Planning Application No 3/2023/0156

Dog and Partridge, Hesketh Lane, Chipping, PR3 2TH
FOR THE ATTENTION OF

I would like to comment on incorrect information still given in the amended drain layout plan dated 12th June 2023 and the amended drainage strategy issue 27th June 2023.

Rev	Date	By	Drawn
Client HOME LIFE DEVELOPMENTS LTD			
Project RESIDENTIAL RE-DEVELOPMENT THE DOG & PARTRIDGE CHIPPING WASTON			
Title SITE LOCATION PLAN WITH SIV OUTFALL DRAIN			
Date: 20/04/2023 Scale: 1:500 File: 20230411			
Ref: C-1050-01

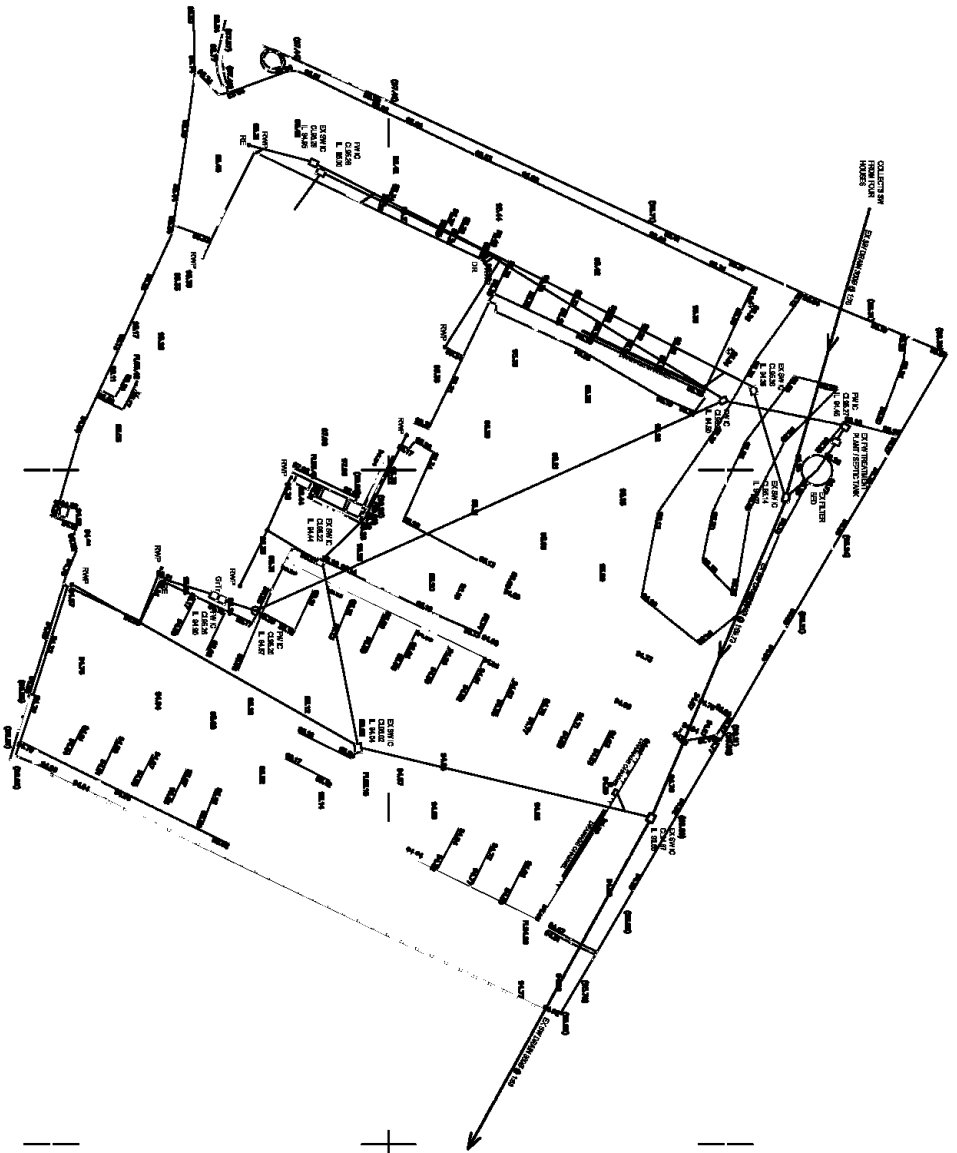
Figure 1 Site location plan does not show the first and largest property Beech House (formerly an Old Folks Home) which is where the SW private pipe originates. There should be five houses on this map for it to be correct.

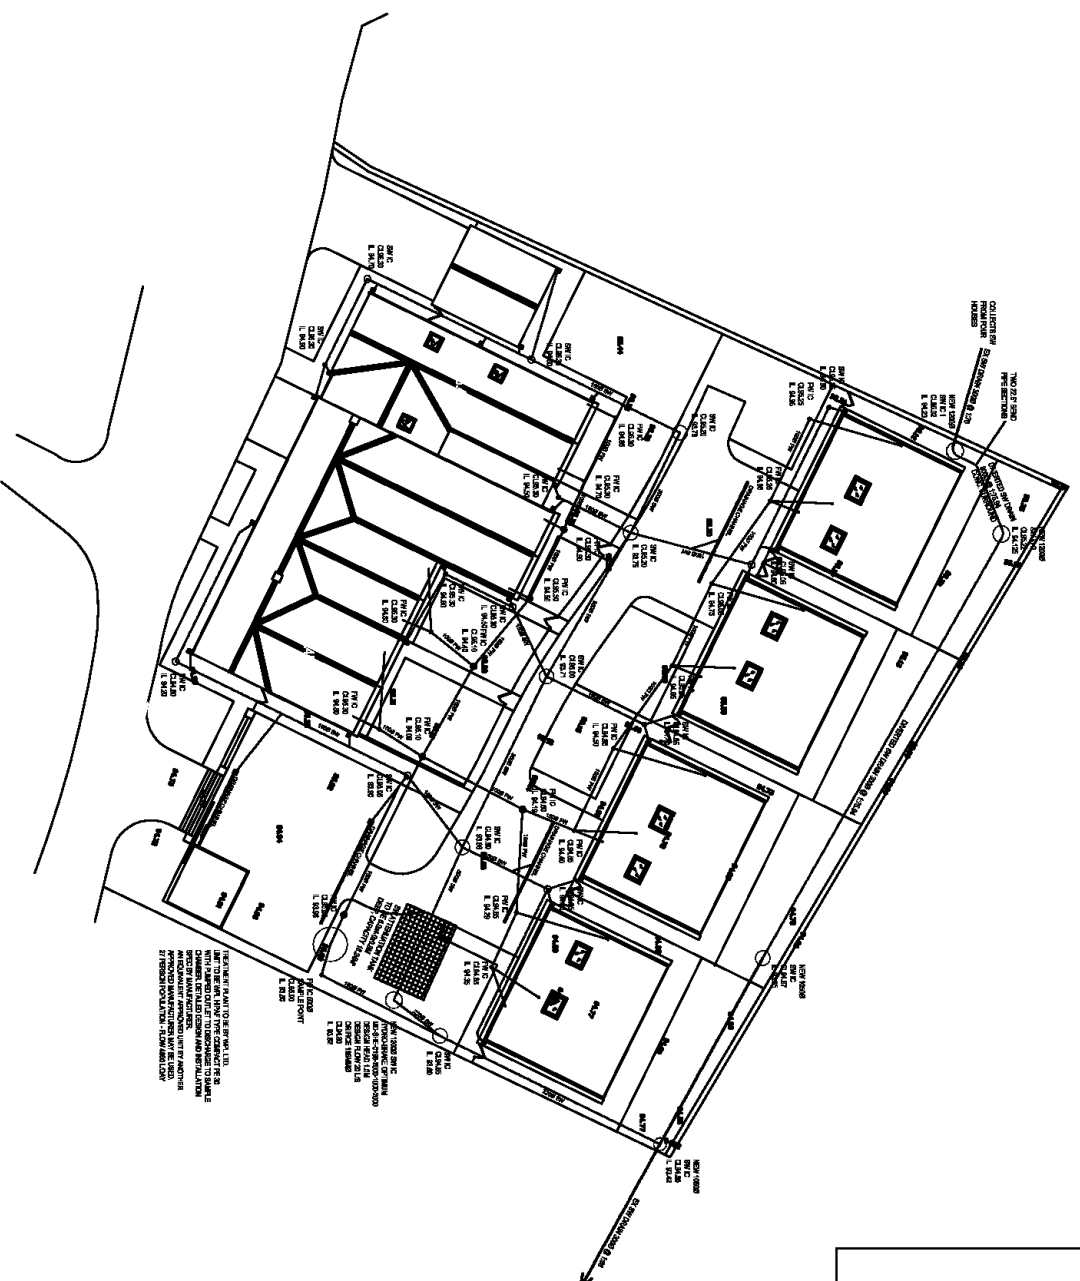
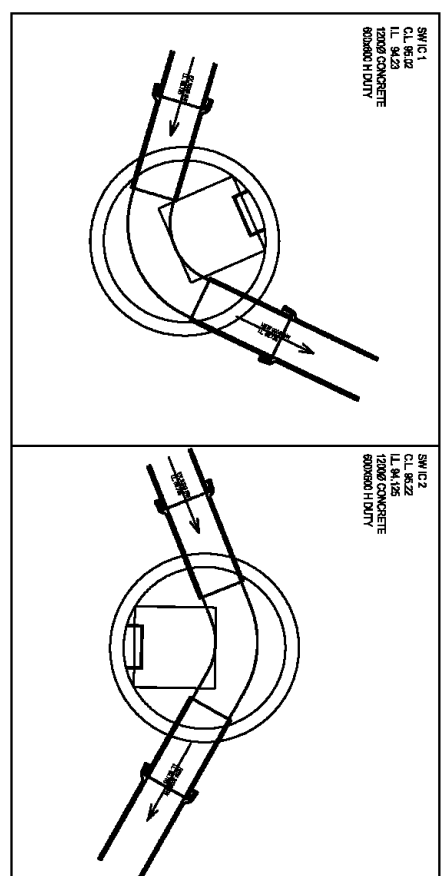
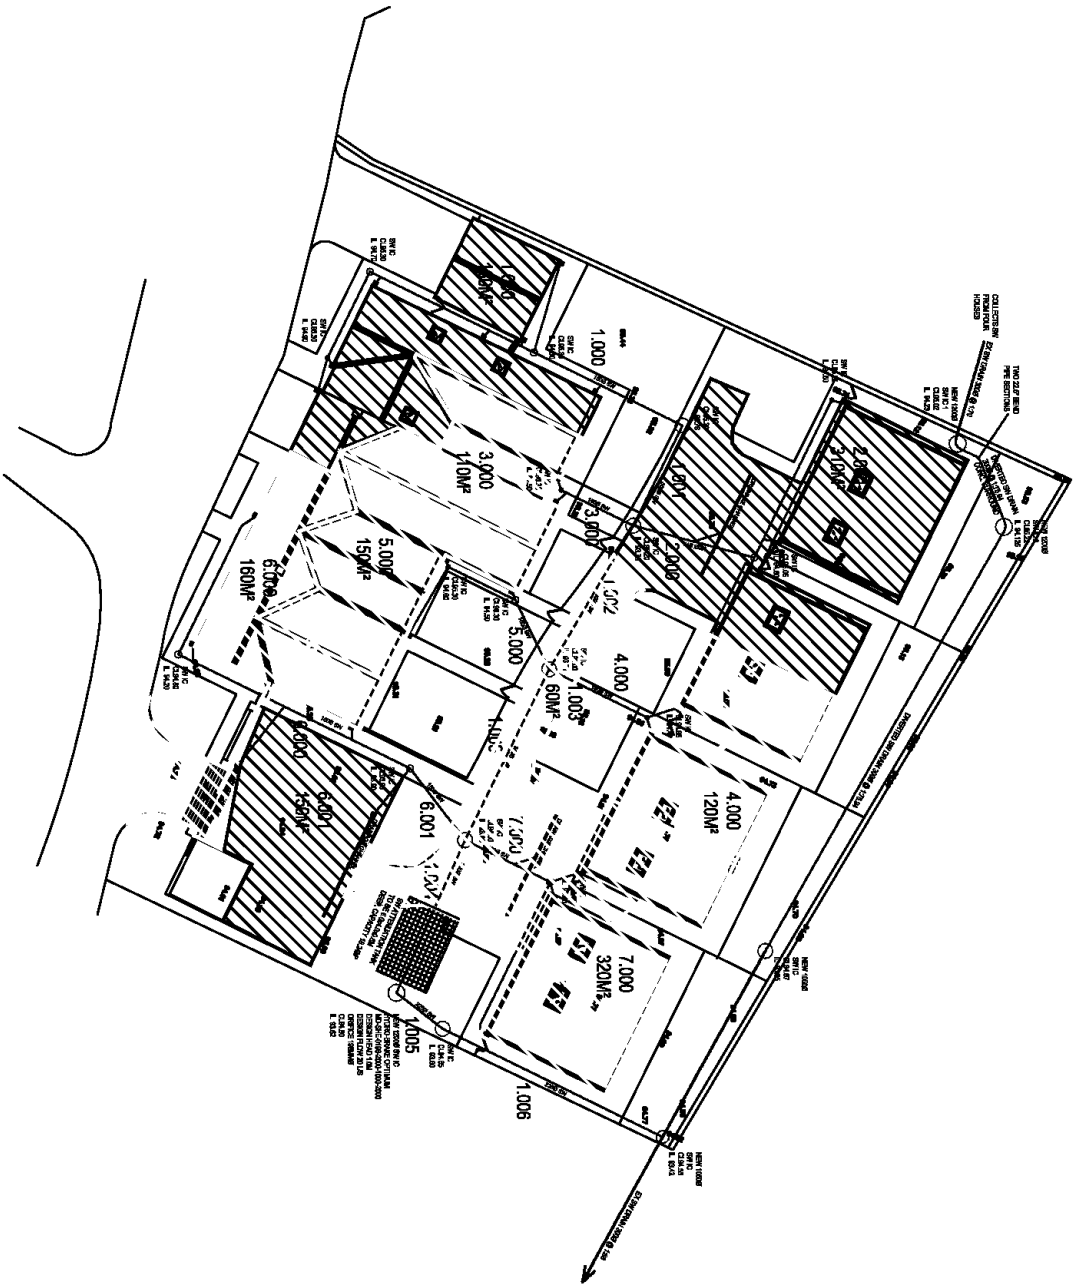
Figures 5,6 & 7 state SW pipe collects from four houses when it should state five houses. The size of the existing pipe collecting SW states 300mm when it should be 230mm and the outlet exit to the existing SW pipe states 300mm when it is the old measure of 9 inches or 230mm.
